DE-2025/112

06 November 2025

Development	State Significant Development (SSD-76440958) – South House – Mixed Use Development with Infill Affordable Housing (WIN Grand) – Request to Provide Advice on the Environmental Impact Statement (EIS), the Proposal and Recommended Conditions
Location	Lot 4 DP 17979, Lot 5 DP 17979, and 1 more, Lot 1 DP 112417, Lot 100 DP 774957, Lot 9 DP 551157, Lot 8 DP 546125, Lot 1 DP 220513, Lot 2 DP 17979, Lot 3 DP 17979, Lot 1 DP 17979, Lot 7 DP 878243, Lot 1 DP 1135333, Lot 1 DP 183348, Lot 1 DP 226374, and 1 more, Lot 1 DP 82673, Lot 1 DP 117019, Lot 1 DP 302824, Pt Lot 1 DP 927806 Lot 1 DP 1087986 WIN Grand - Burelli, Crown & Kiera Streets WOLLONGONG NSW 2500

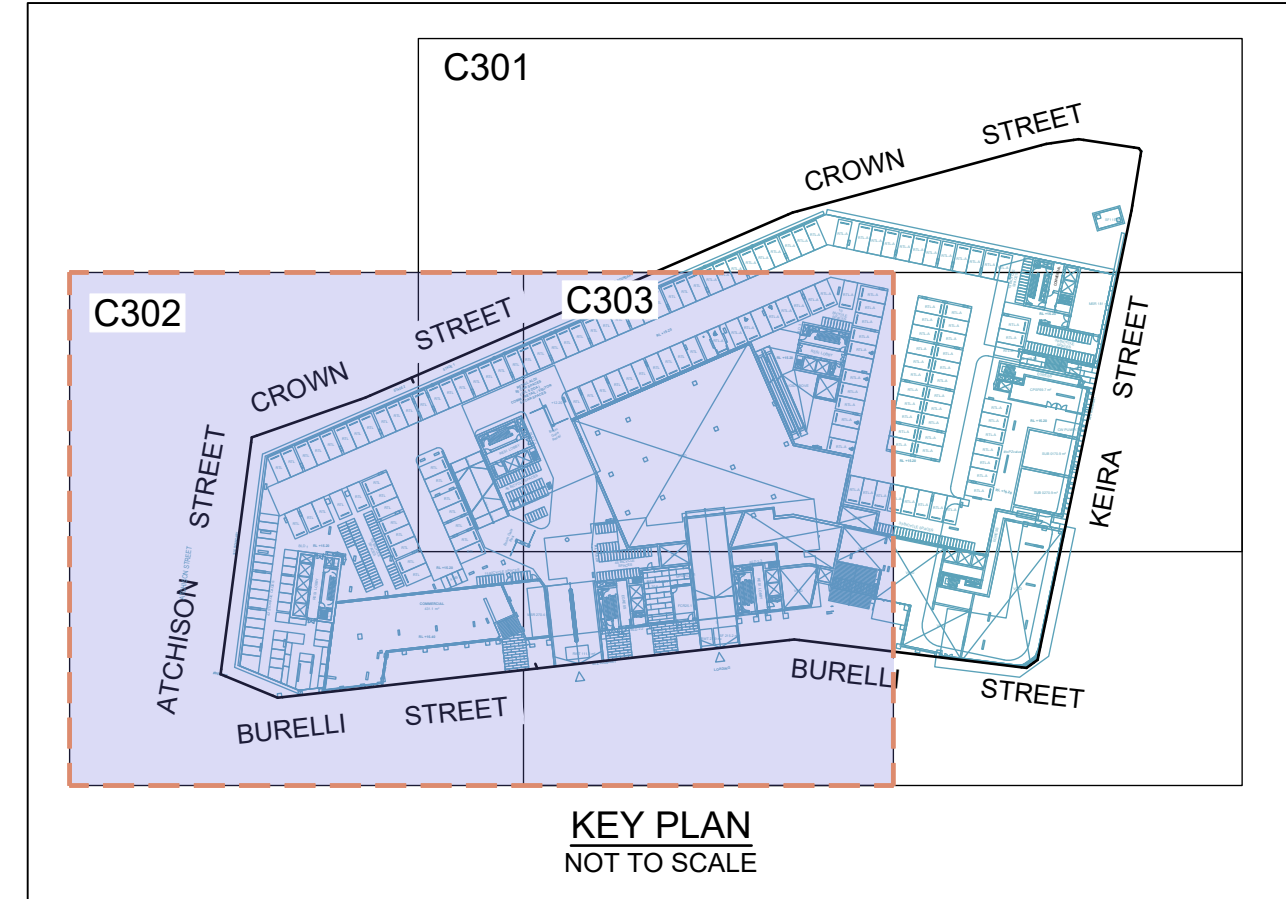
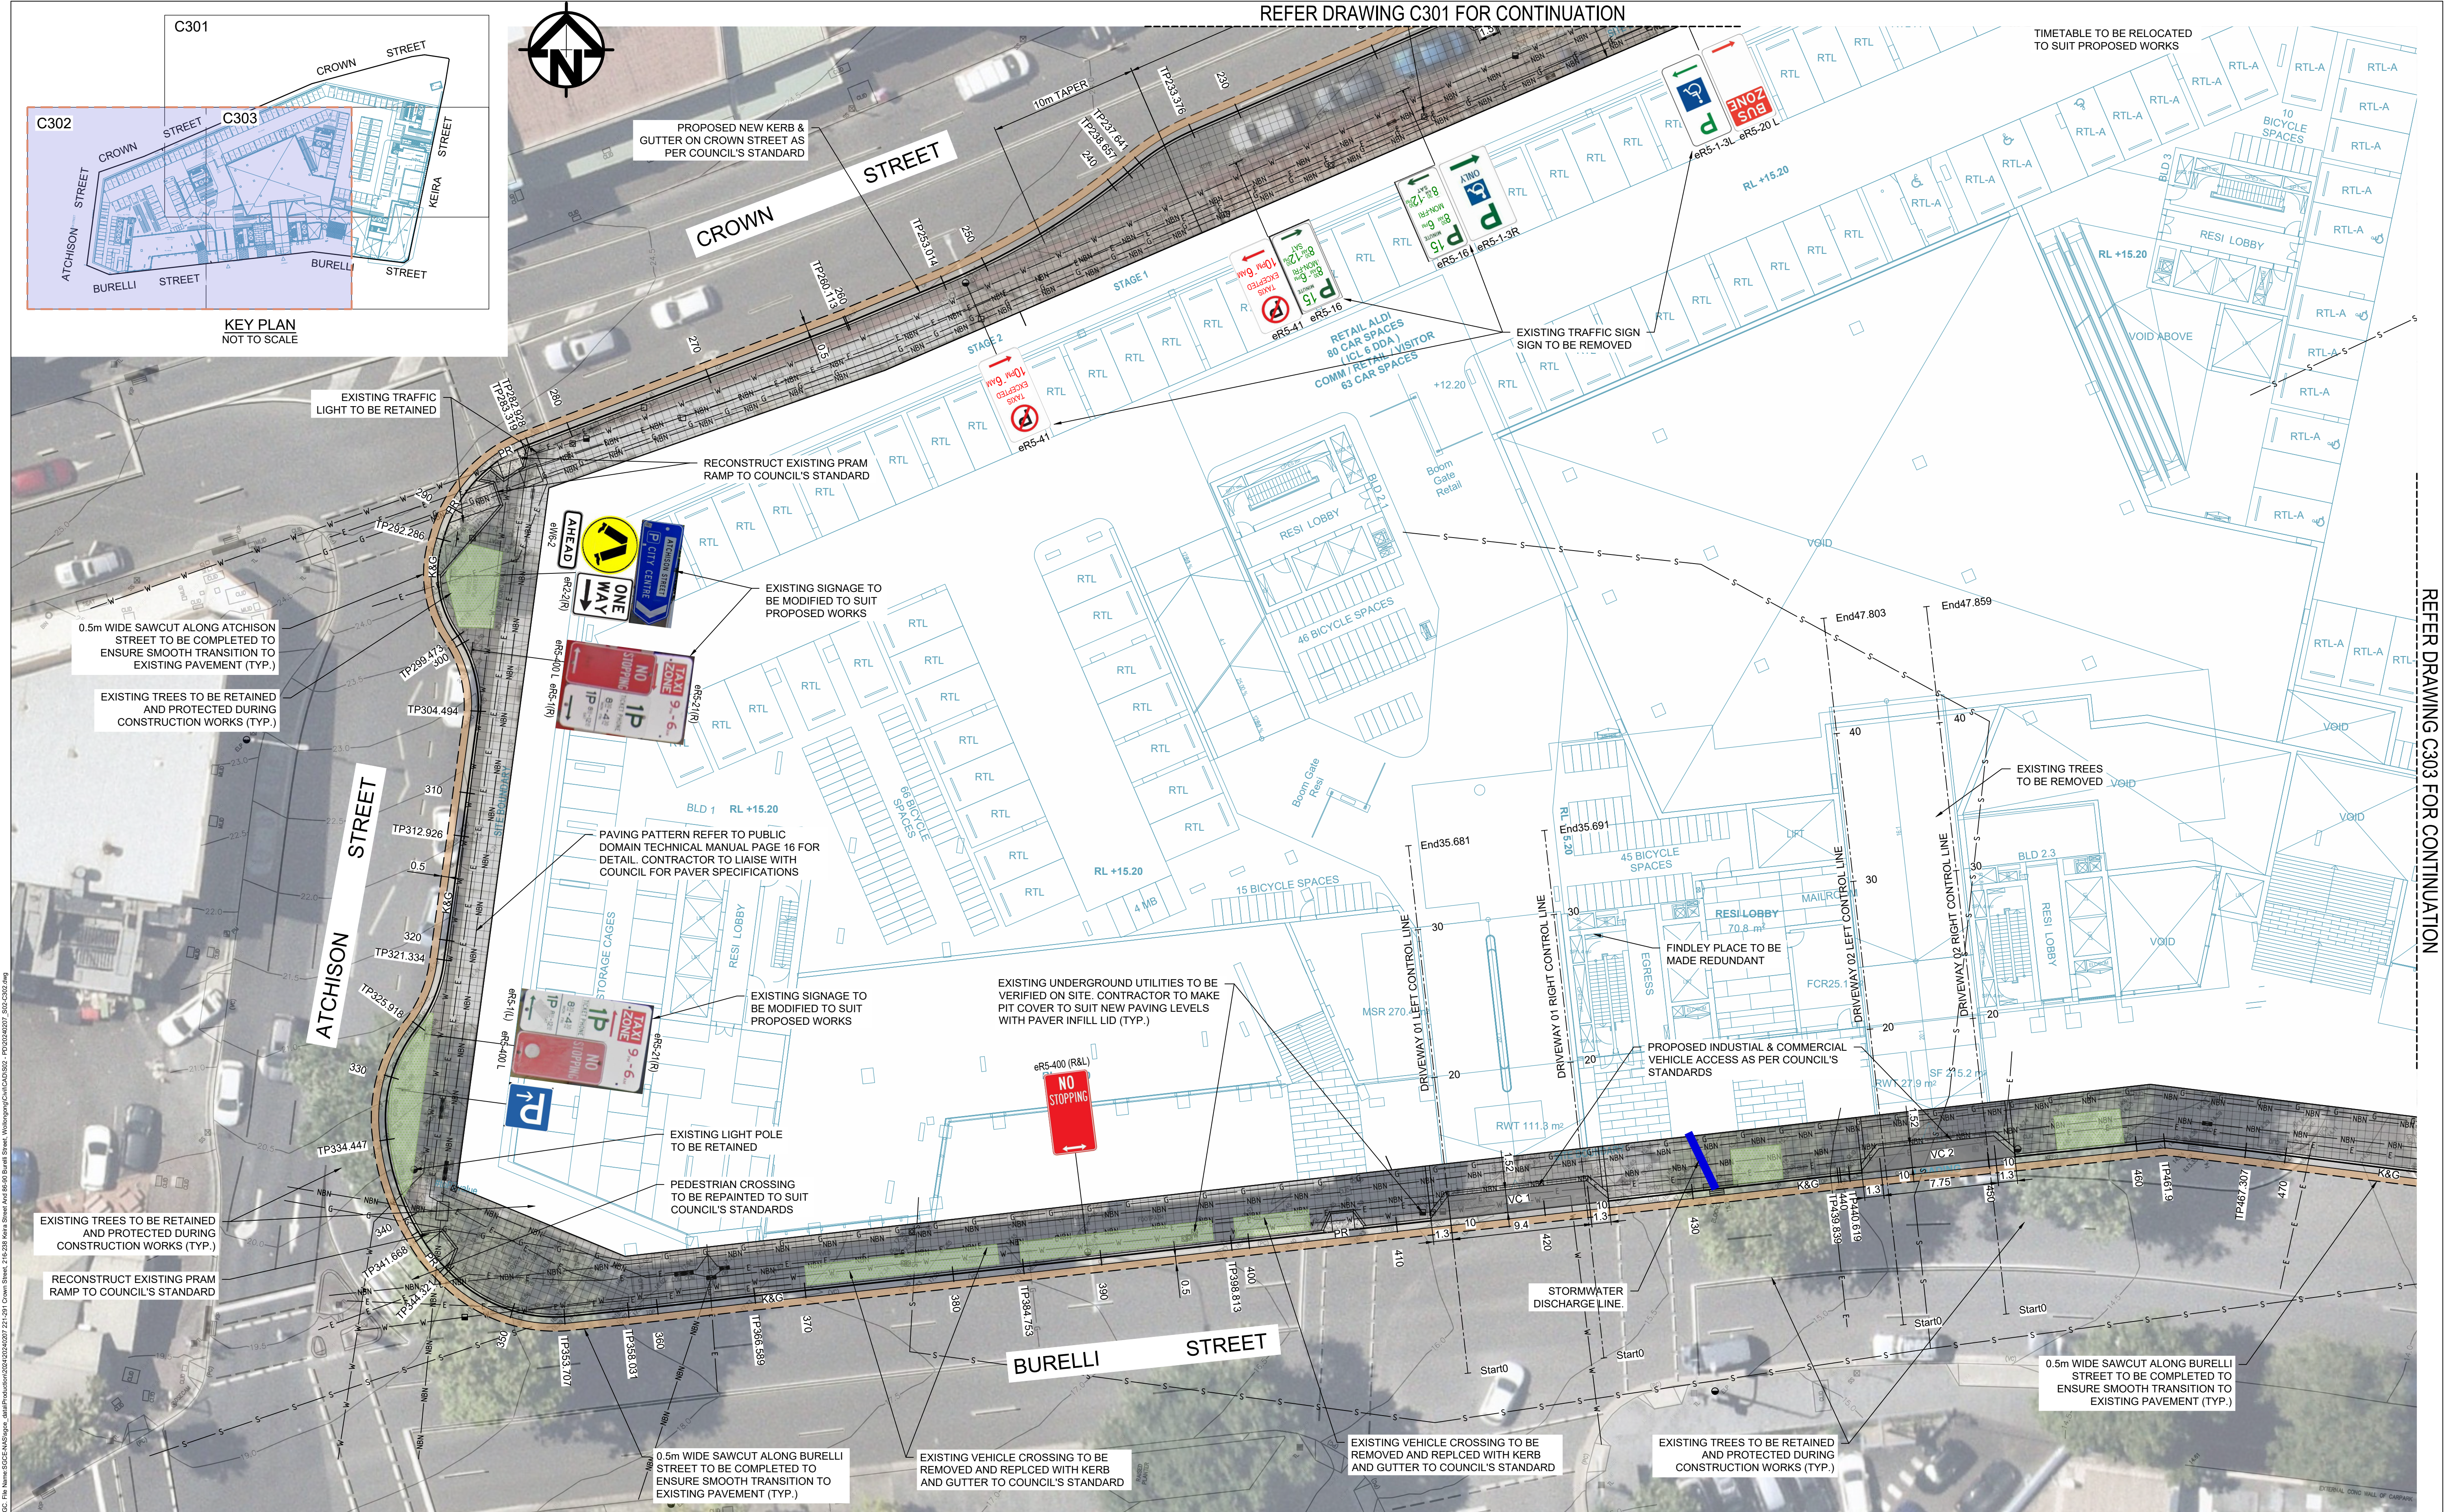
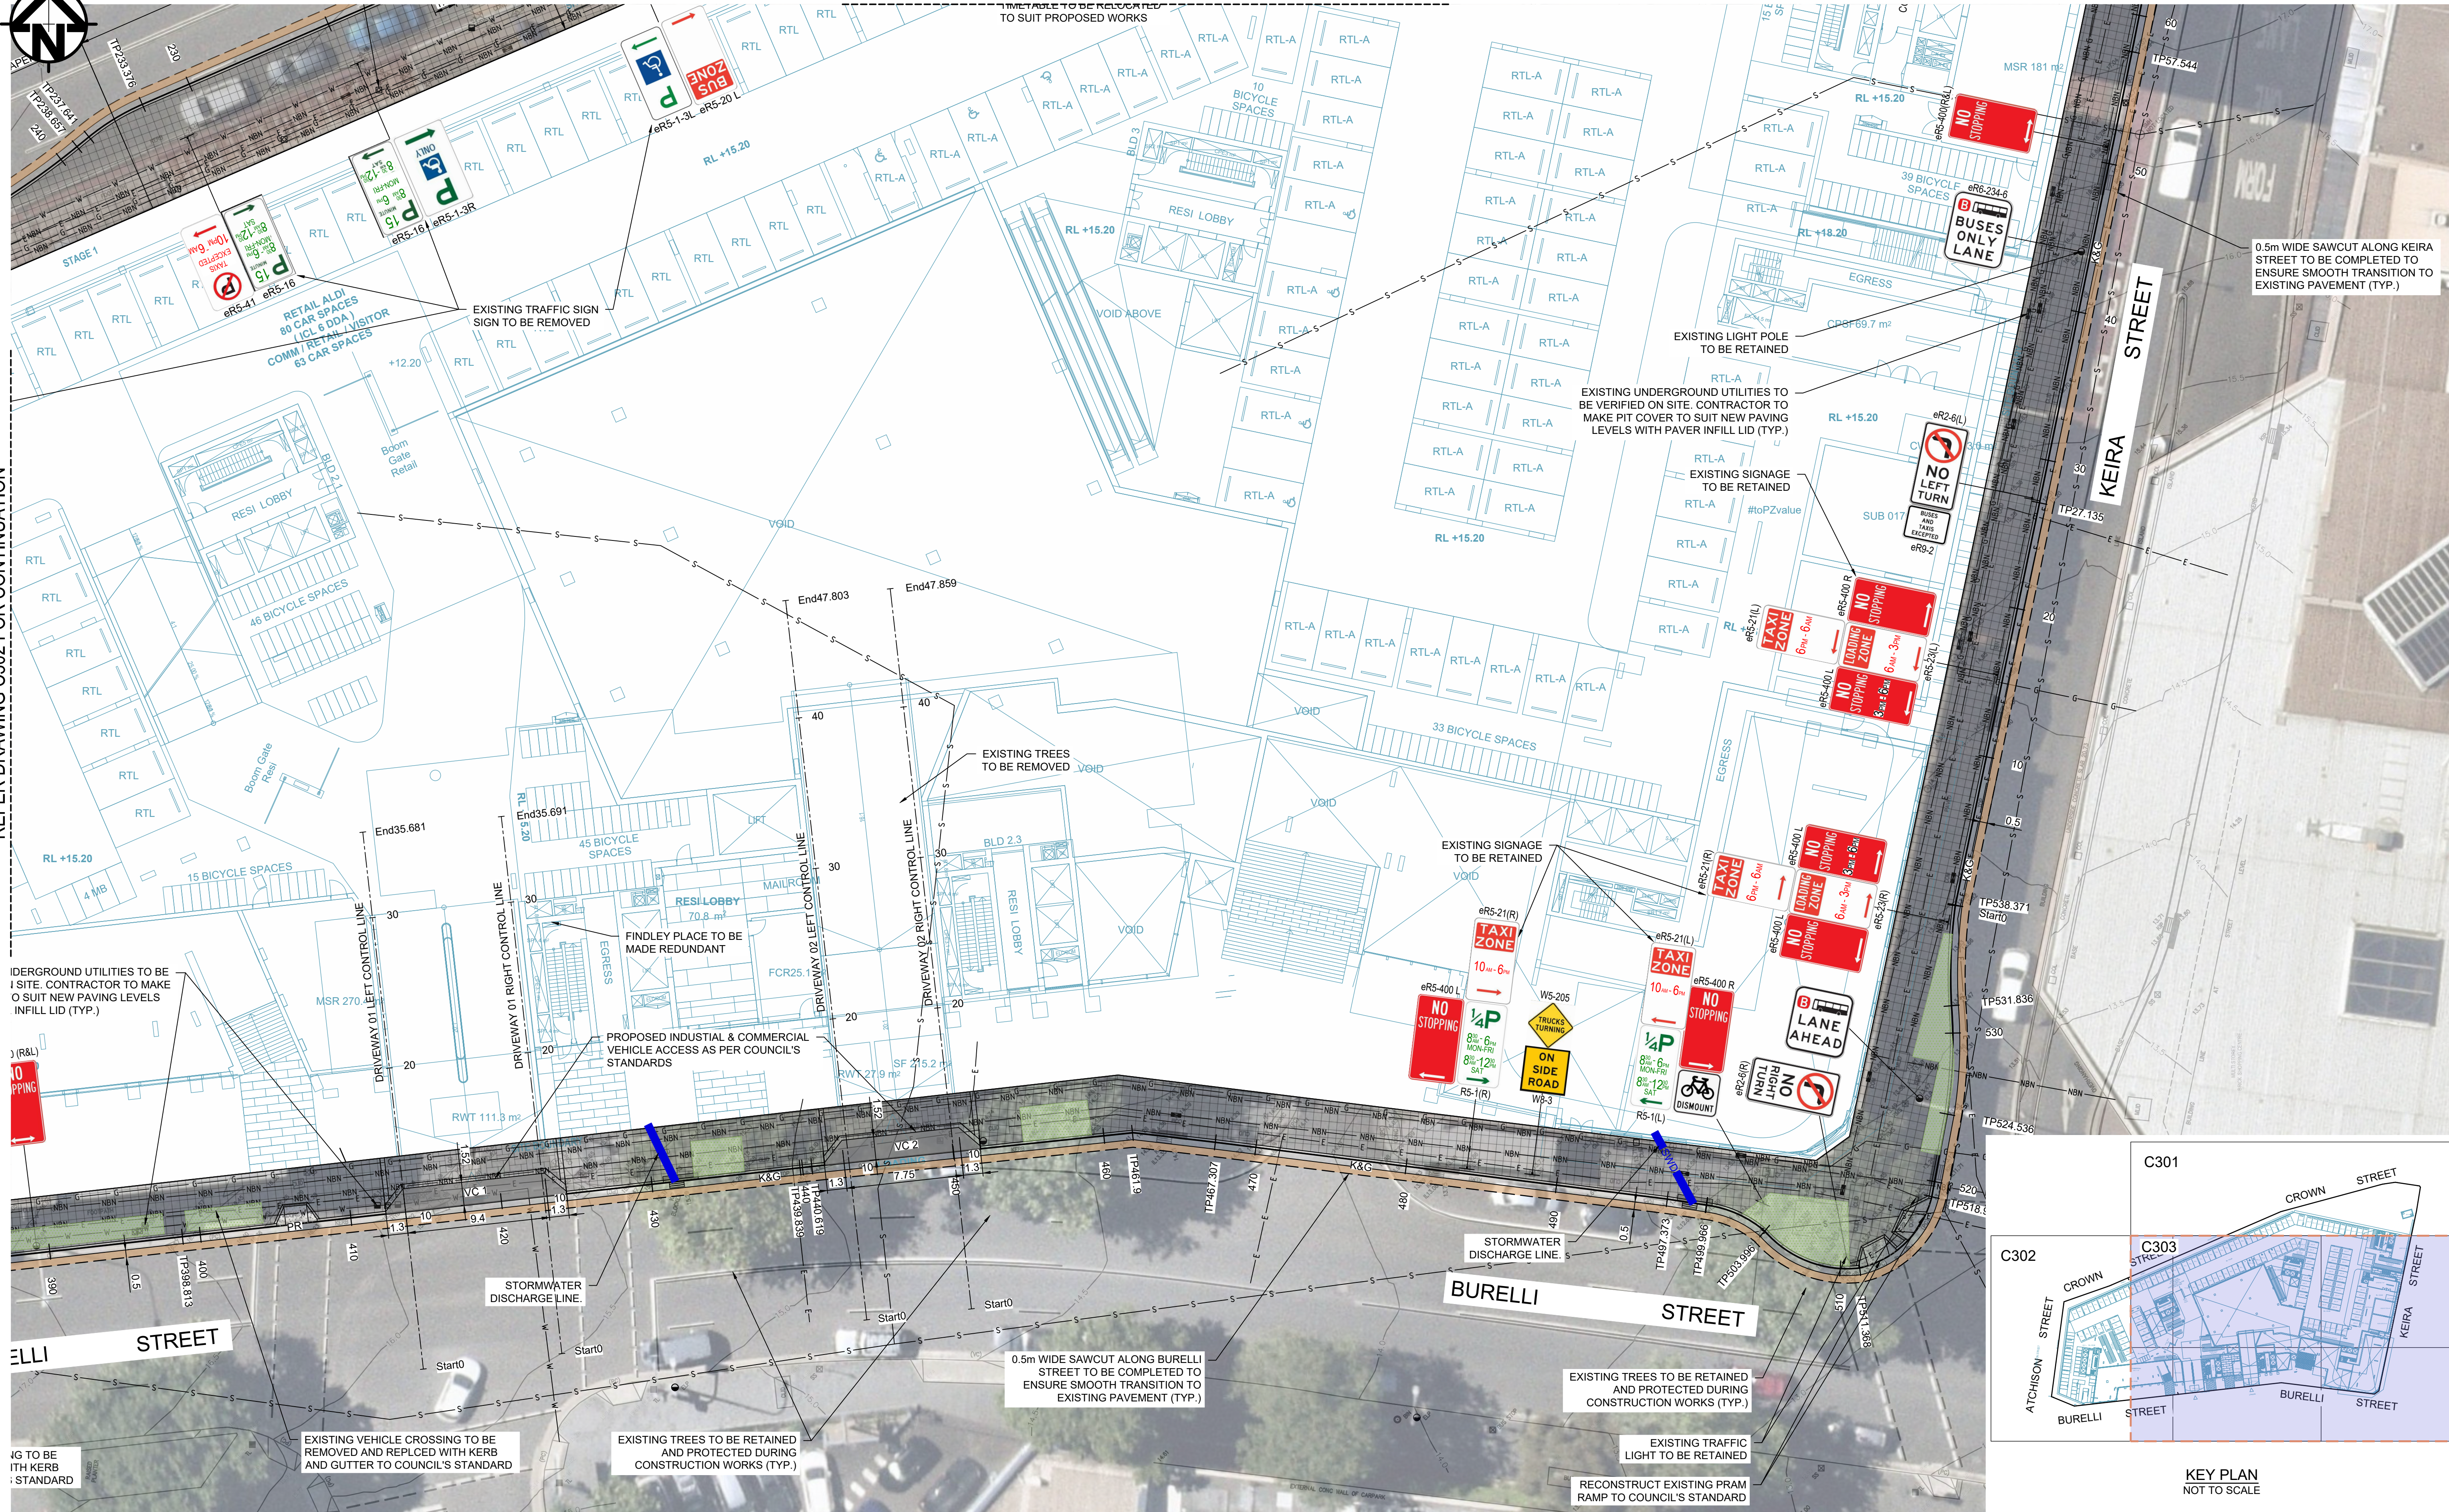
- 4(b), 4(e)(x) and 4(e)(xi): the following concerns are raised regarding the public domain:
 - Under DA-2021/957, extensive work was done to establish the desired footpath levels and widths along with kerb alignments for the perimeter of the block. Those design drawings involved lengthy consultation with relevant stakeholders within Council and Transport for NSW should be maintained under the current proposal as they are essential to achieving necessary pedestrian amenity, incorporate bus stops, taxi zones and the like. The detailed design drawings have been previously provided to the proponent and the sDRP.

- Detailed sections and elevations from kerb to building entries are required that reflect these design drawings for the full frontage of the development.
